Engineers comments;

The level of detail supplied is currently insufficient to enable the discharge of conditions 11, 13 or 14.

Figure 1
Groundwater Level at all Boreholes

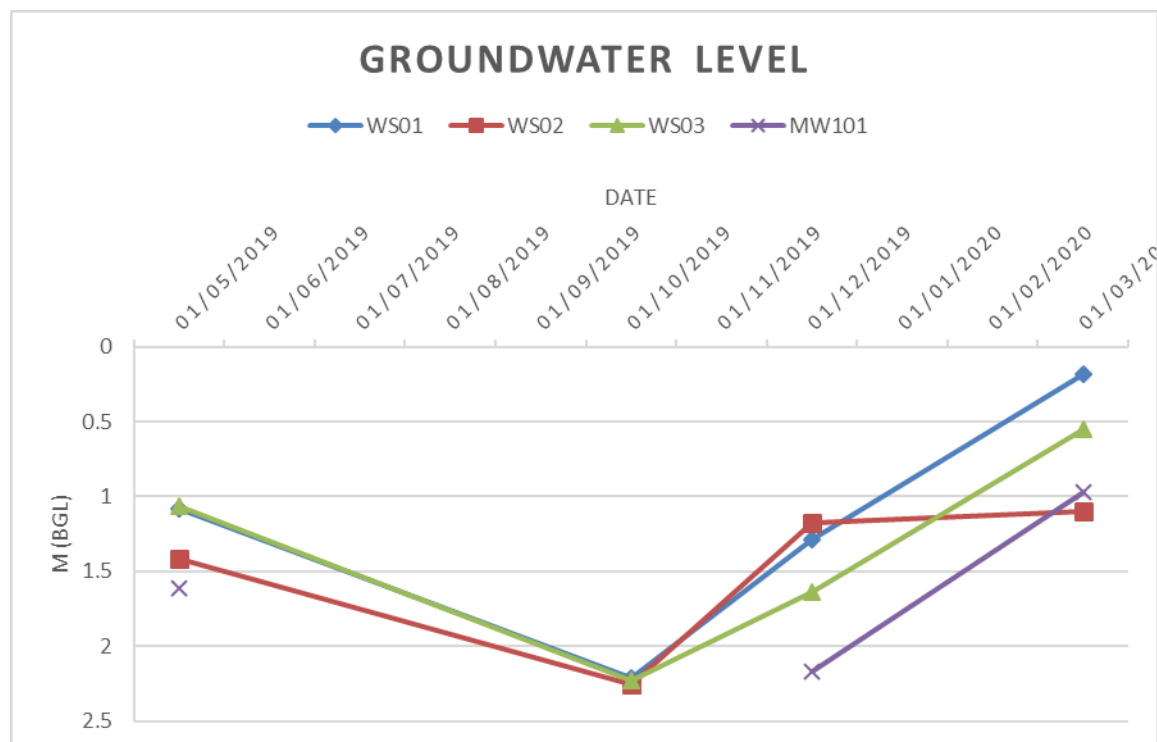
Firstly, we need to be sure that shallow infiltration is not possible, as part of an overall scheme. Please provide a plan showing all the groundwater monitoring point locations and the monitoring results for all, not just WS02. Achieving 1m freeboard between the base of structures and the peak recorded groundwater level is not a requirement in this particular area, so long as the base is above the peak recorded level. This information will dictate as to whether shallow winter infiltration testing will be required.

Figure 4
Route 1 Plan and Section AA'

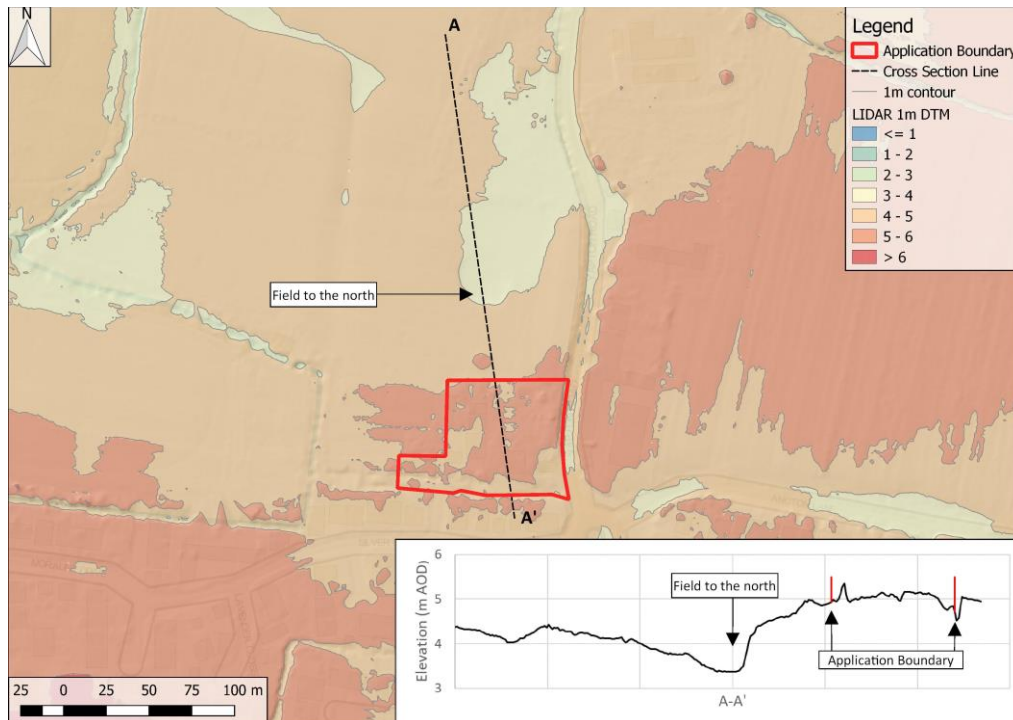
The applicant should also provide topographical evidence to show that no overland/exceedance run off flows from the field to the north will have any detrimental effect on the development/suds.

Site: YAPTON POULTRY FARM
Project: MIDDLETON RESIDENTIAL
Date: 01/07/2020
Drawing: SITE VISIT DISCUSSION
APPENDIX 02

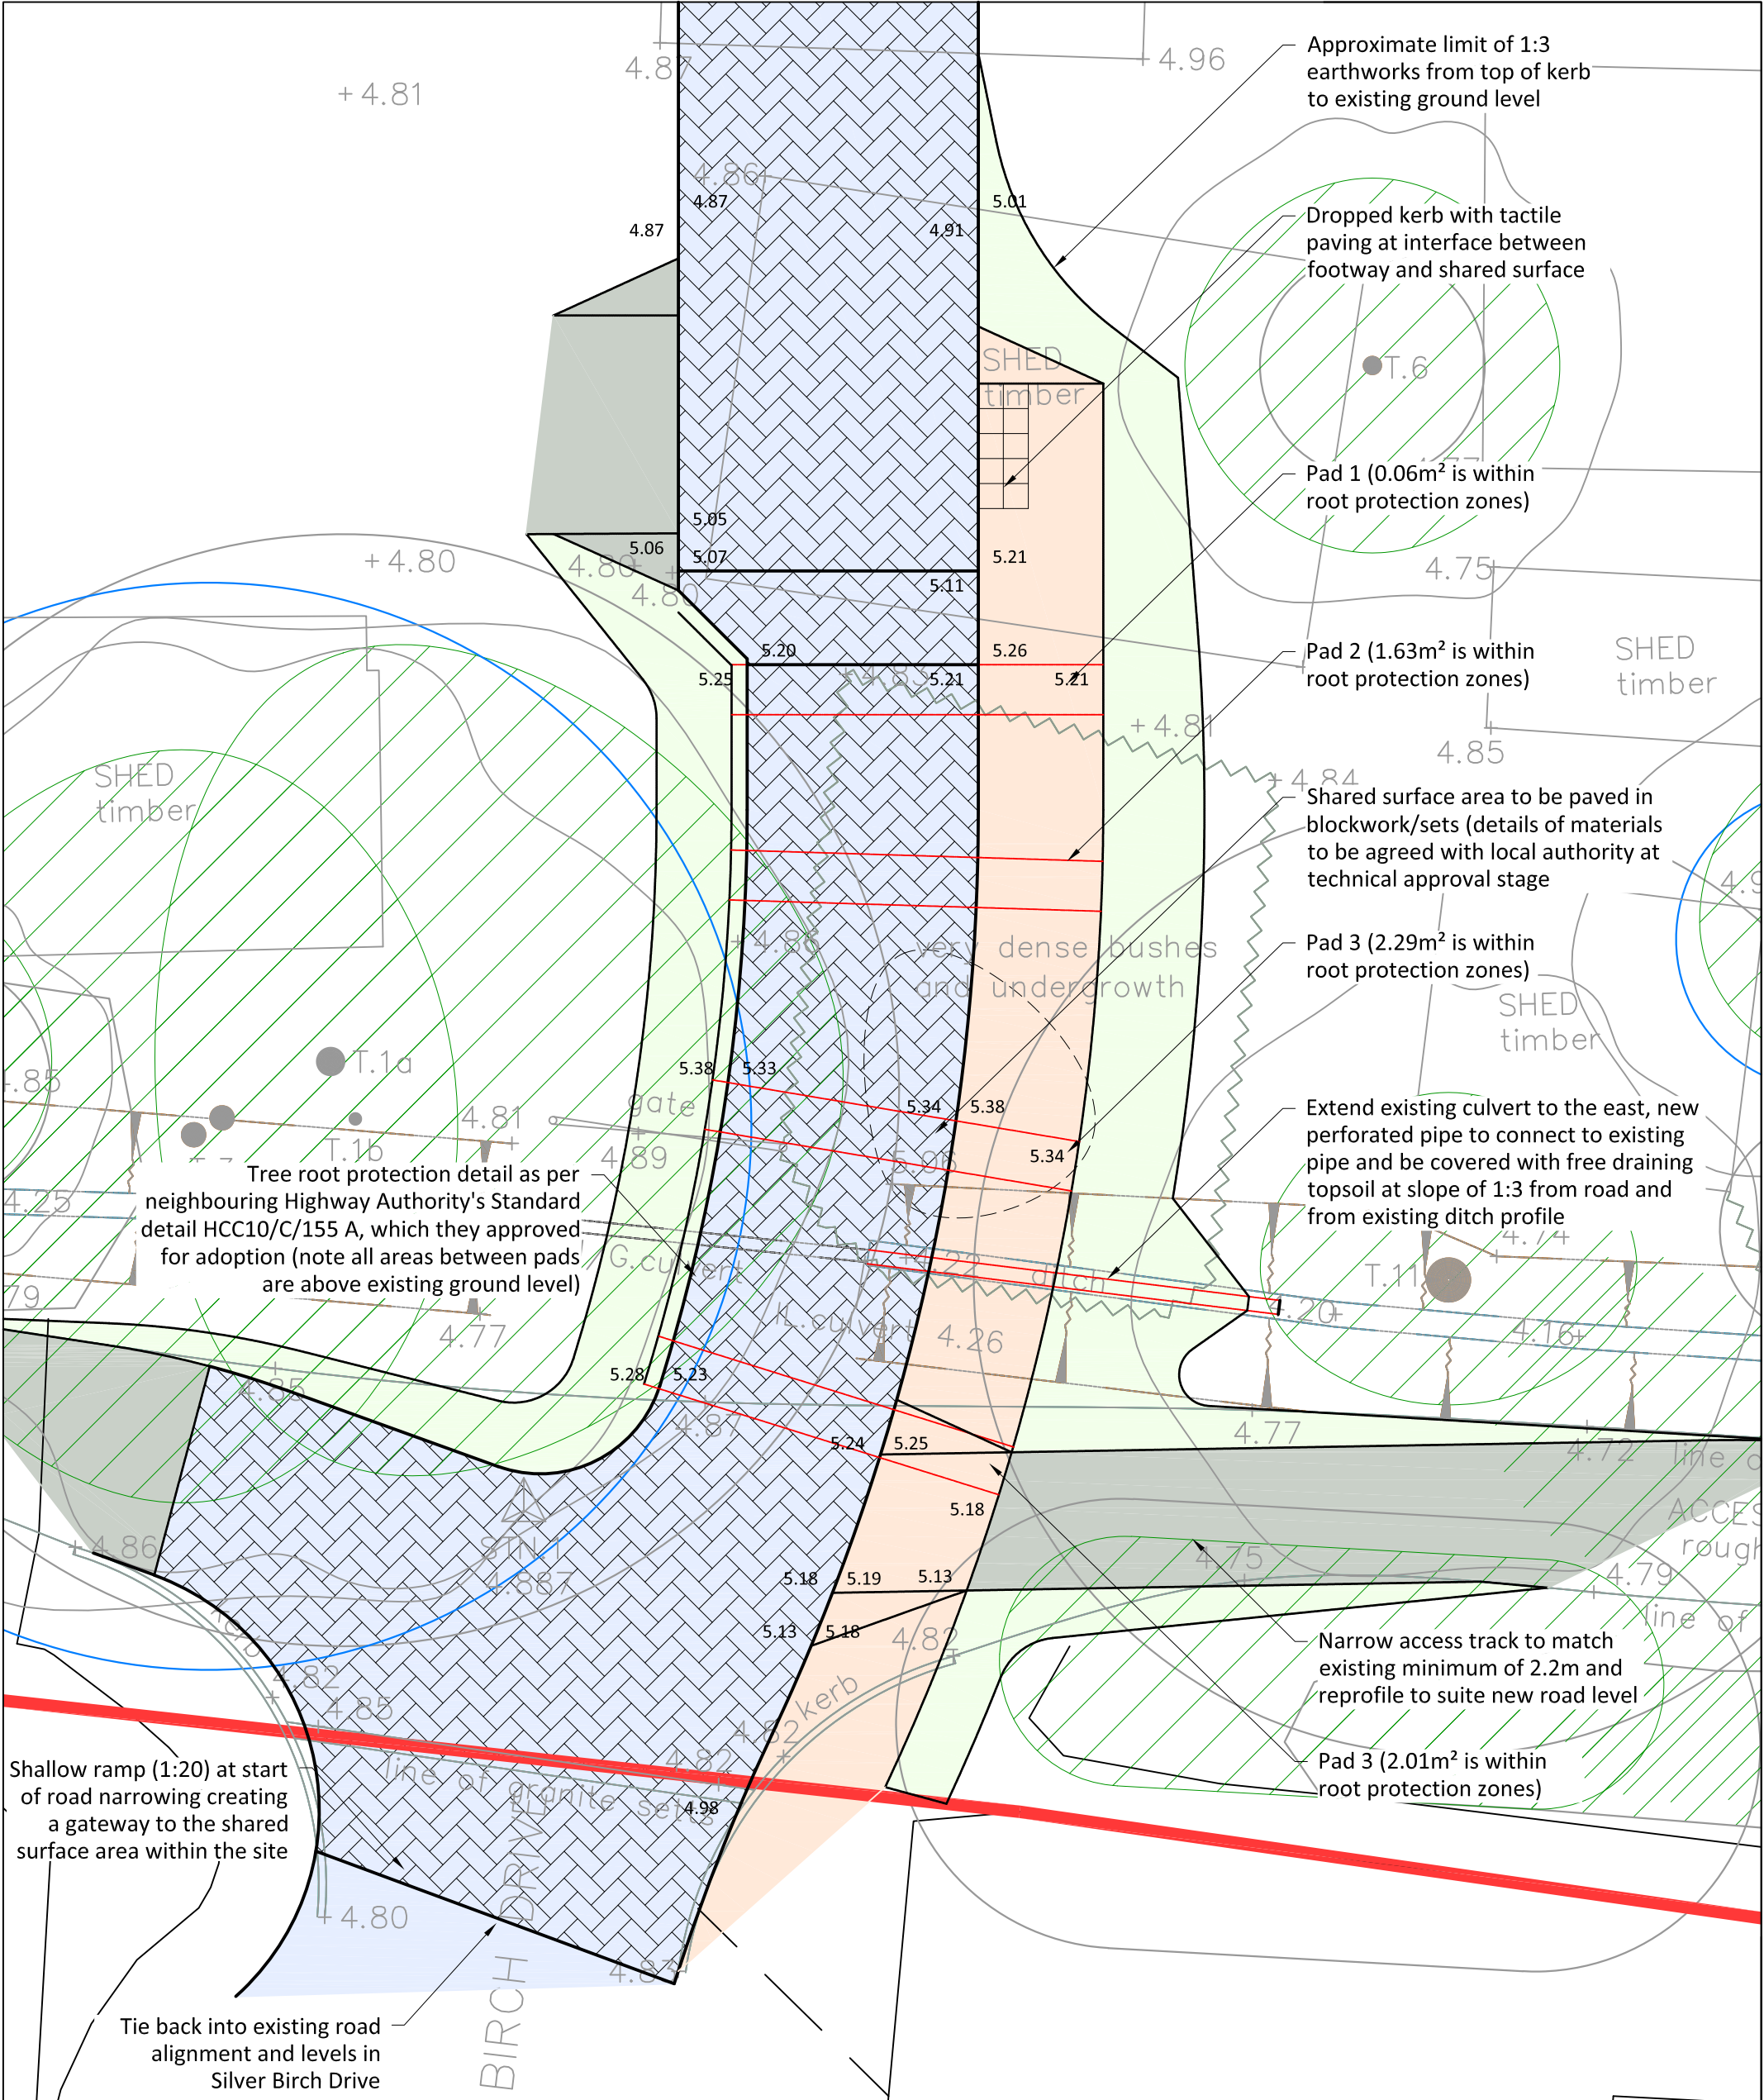
Regarding the ditches on the southern boundary, it is very likely that these will need improvements and I suggest a meeting takes place on site to look at these. Land Drainage Consent will be required for any alterations to them, including culverting and any discharge structures. This will all need to be fully detailed on the drawings.
